CONSTRUCTION TRAFFIC

Navenby Parish Council asked (REP2-046) that all construction traffic (not just HGVs) should avoid Navenby (i.e. along or crossing Navenby High Street). Navenby Parish Council also asked that the outline CTMP commit to more more specific enforcement measures (such as ANPR cameras at site compounds). In addition, the Parish Council asked that it be consulted about the final CTMP.

Figure 3-8

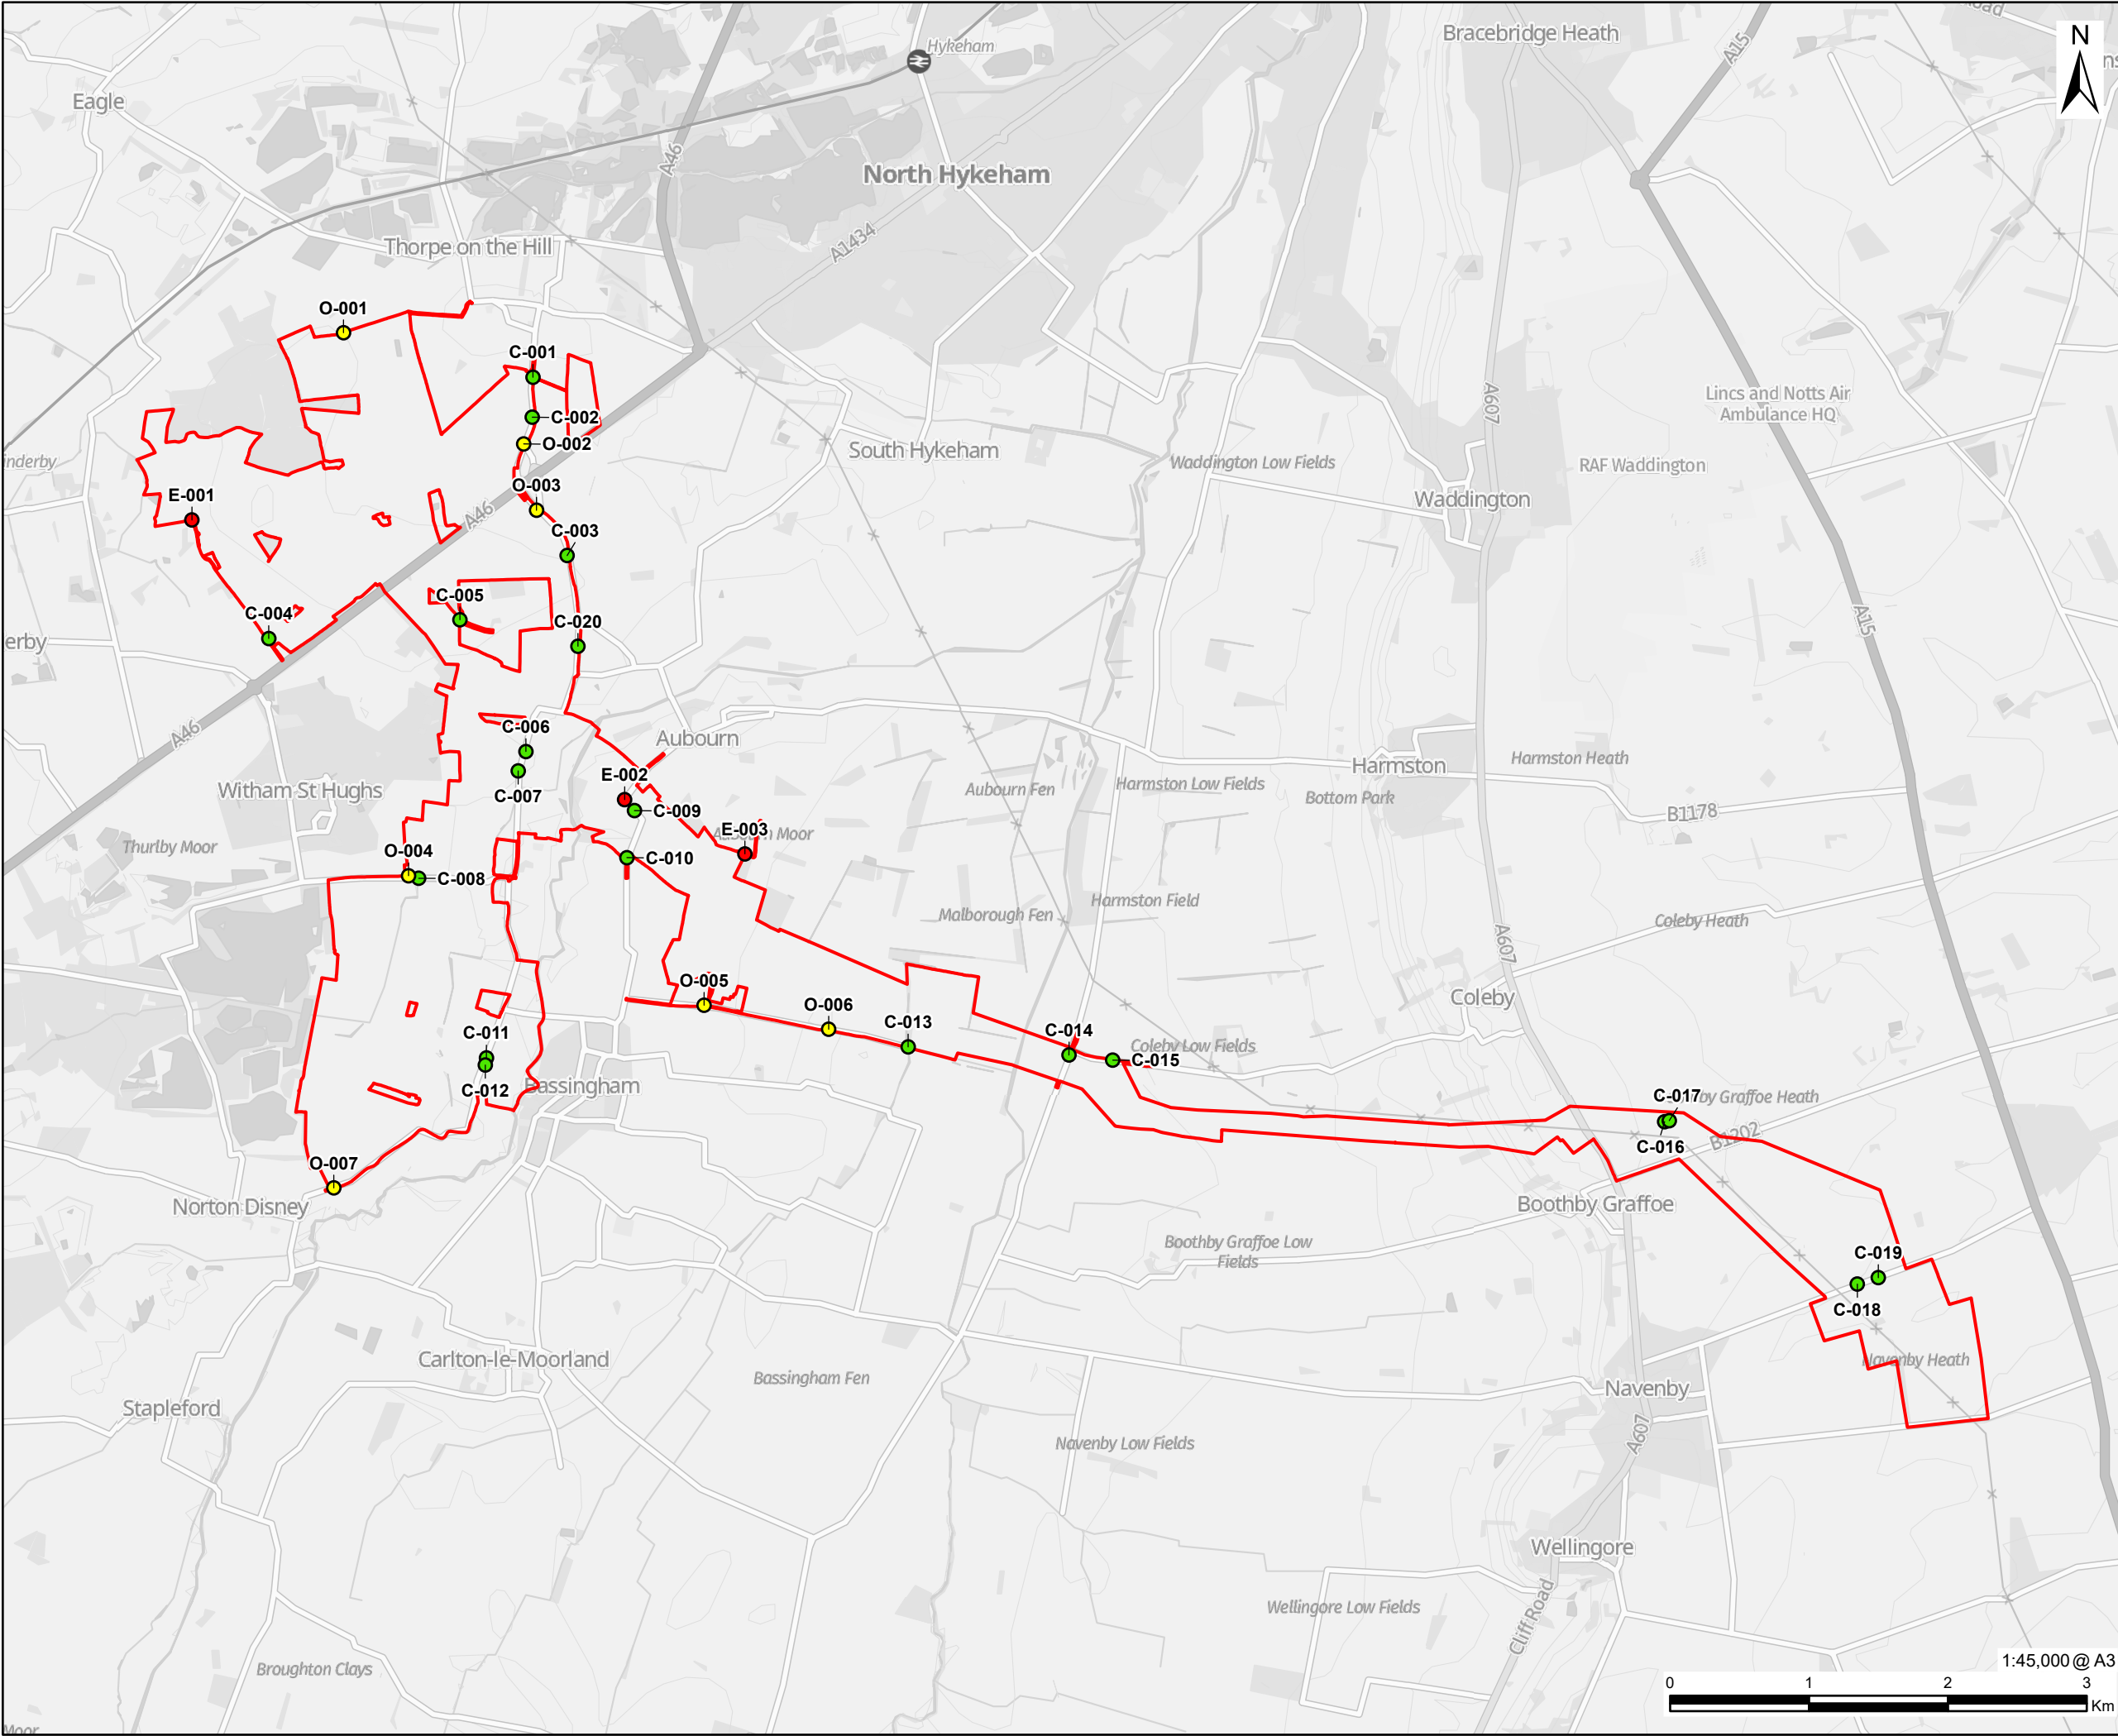
There has been recognition of community concerns about traffic in the case of Springwell. The community does not feel there has been sufficient recognition of concerns in relation to Fosse Green. Navenby Parish Council was seeking assurance that in relation to Fosse Green, construction traffic (not just HGVs) would not pass through Navenby village and that there would be use of cameras at site accesses. In the light of continued community concern, will both the Applicant and Lincolnshire County Council confirm that they wish to avoid construction traffic passing through Navenby, cameras will be placed at site accesses and that the final CTMP will be the subject of consultation with Navenby Parish Council. REP4-014 is the applicant's response to four comments on traffic that I made in REP3-082 and REP3-083; I wish to express concern about several parts of the applicant's responses.

First, the applicant said the non-disclosure of the serious collision on Green Man Road was because it "occurred outside the extents of this study area, and beyond the extent of the road used by traffic travelling from the A15 to the site access". Even if not on the part of the road between the A15 and the site access, if the applicant is not accepting that non-HGV be restricted from that part of Green Man Road, the whole of the road should be in the study area.

Second, the applicant said LGVs would not be allowed on site before 9.00 but did not address my point that restriction could lead to them waiting in Navenby village until they are allowed on site.
